OXFORDSHIRE COUNTY COUNCIL'S RESPONSE TO CONSULTATION ON THE FOLLOWING DEVELOPMENT PROPOSAL

Application no: 14/01932/OUT-2

Proposal: Outline - Development of up to 1,000 dwellings together with a mixed use local centre. [including A1 retail up to 1,000 m2, financial services (A2), restaurants, pubs and takeaways (A3, A4, A5), community uses (D1)]; primary school and safeguarded additional primary school land; secondary school playing field land; green infrastructure including formal (including playing fields) and informal open space, landscape and amenity space; changing and sports facilities (including D2); sustainable drainage systems; highway, cycle and pedestrian routes; car parking; infrastructure (including utilities); engineering works including ground remodelling; demolition, site reclamation and removal of structures. Formation of a new roundabout access from the A361 together with associated alterations to alignment of Bloxham Road and provision of a section of spine road through the site up to its eastern-most boundary

Transport

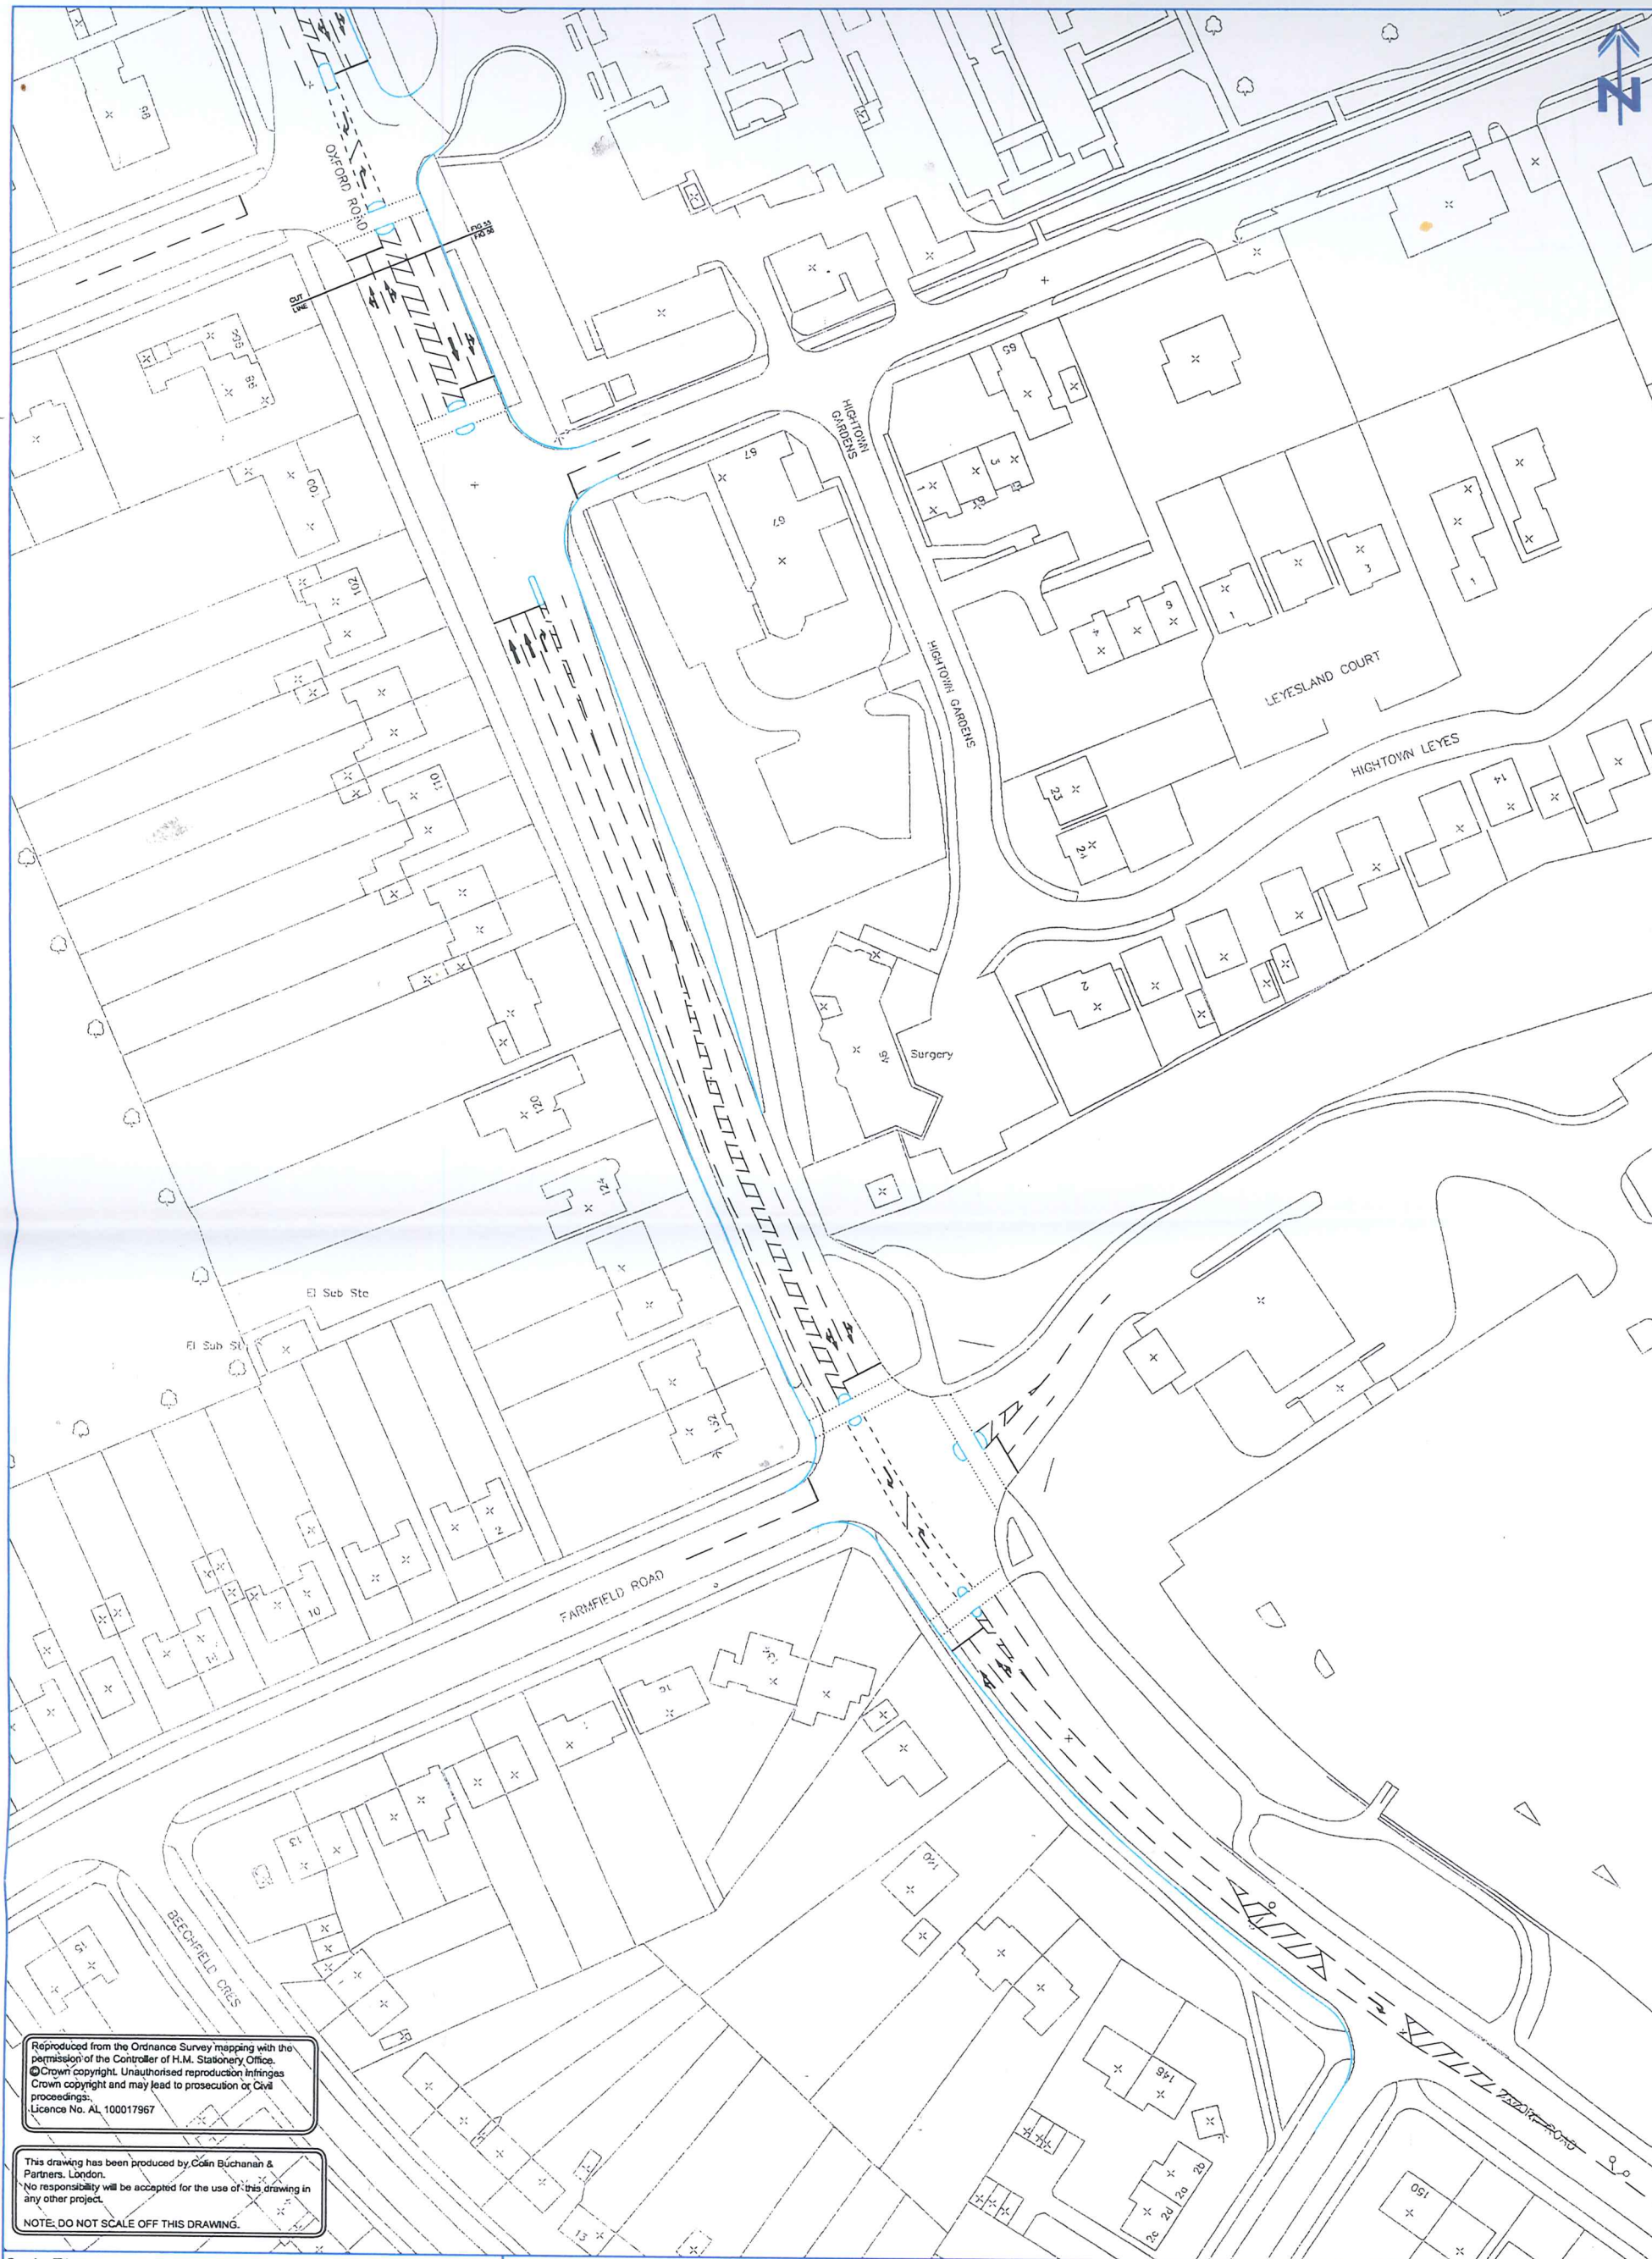
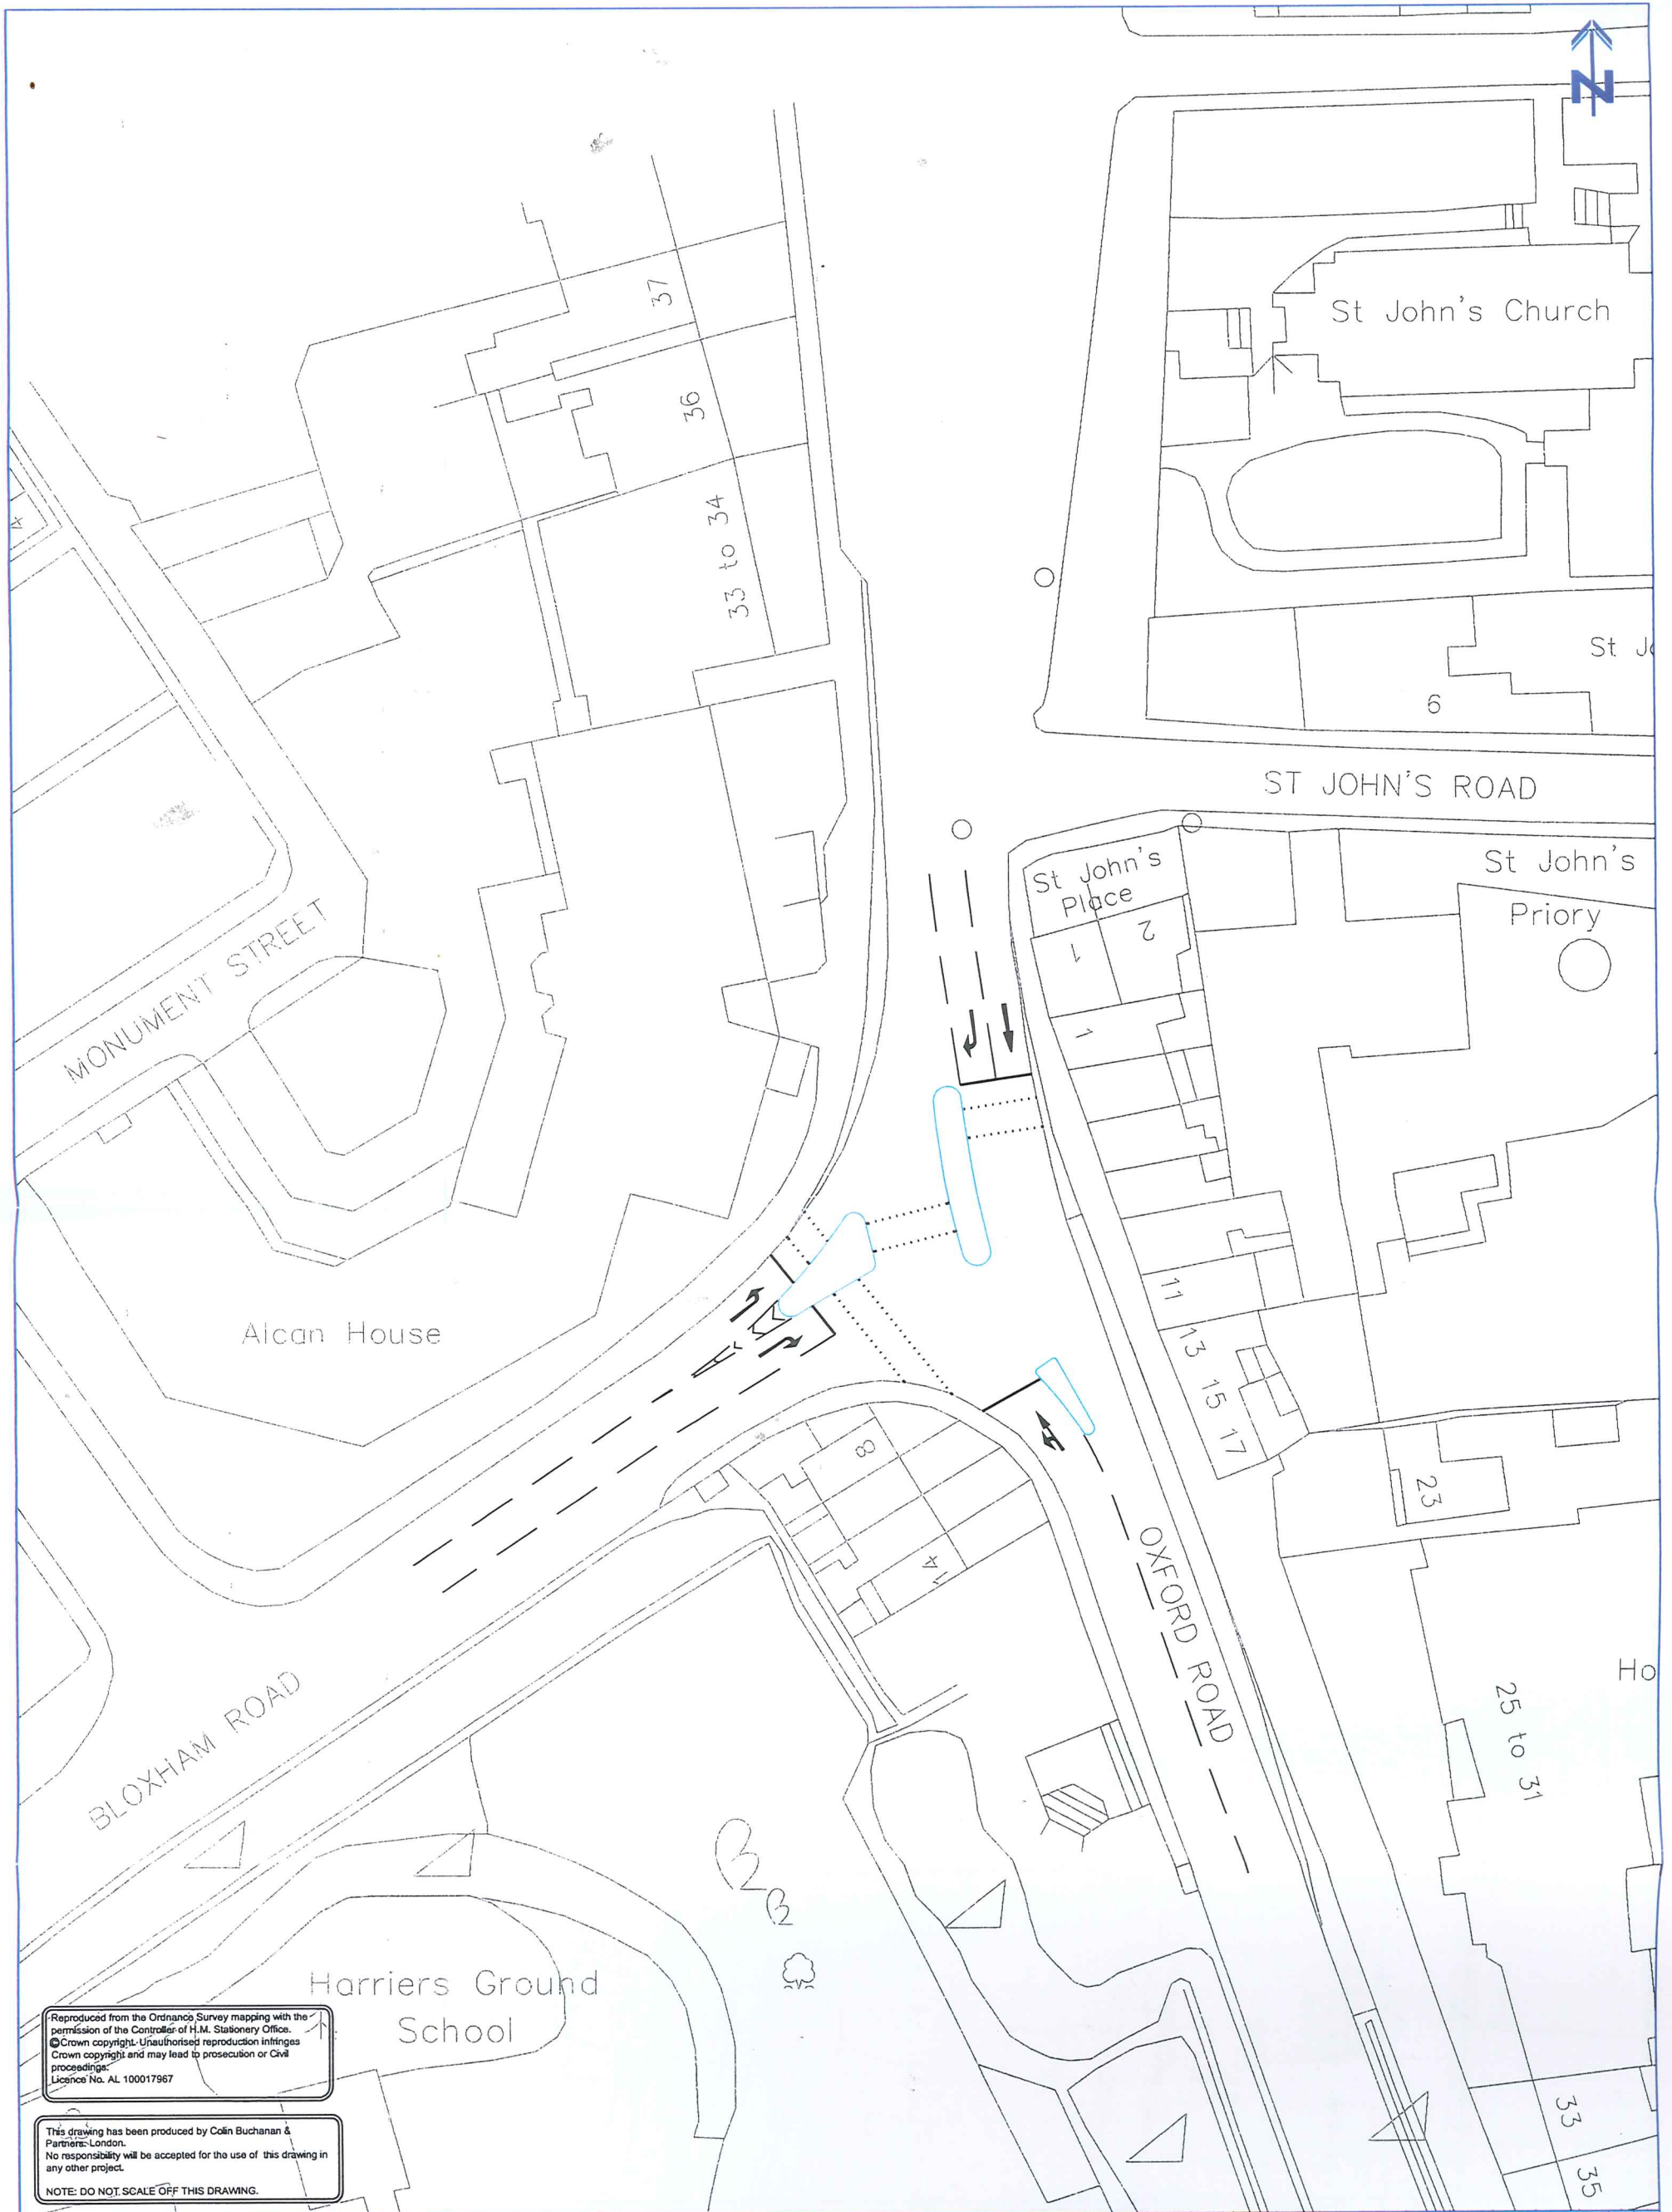
The DS3withLR has lower demand and actual flow on the South Bar Street entry arm than the DS3noLR; and for the movement from Oxford Road to South Bar Street. The Bloxham Road to South Bar Street movement has greater demand in the DS3withLR scenario, which as we know the coding does not appear to effectively use the spine road to distribute traffic on the network. It is therefore my conclusion that the Longford Park design (DS3withLR) better fits the LTP4 aspirations (of the two junction types tested) for the junction and the capacity enhancement proposed is not required.

- a) Bloxham Road/Springfield Ave: OCC proposes that the capacity improvement would be required in the interim stage before the spine road is built, but further funding is required to develop a longer term solution once the spine road is available.
- b) Bloxham Road/Queensway signalisation: OCC considers this would be required early in the development. However, design tweaks are required to better cater for cyclists.
- c) Bloxham Road/South Bar improvements: OCC considers a scheme to be provided from the Longford Park development to be preferable, so this scheme would not be required from this development.
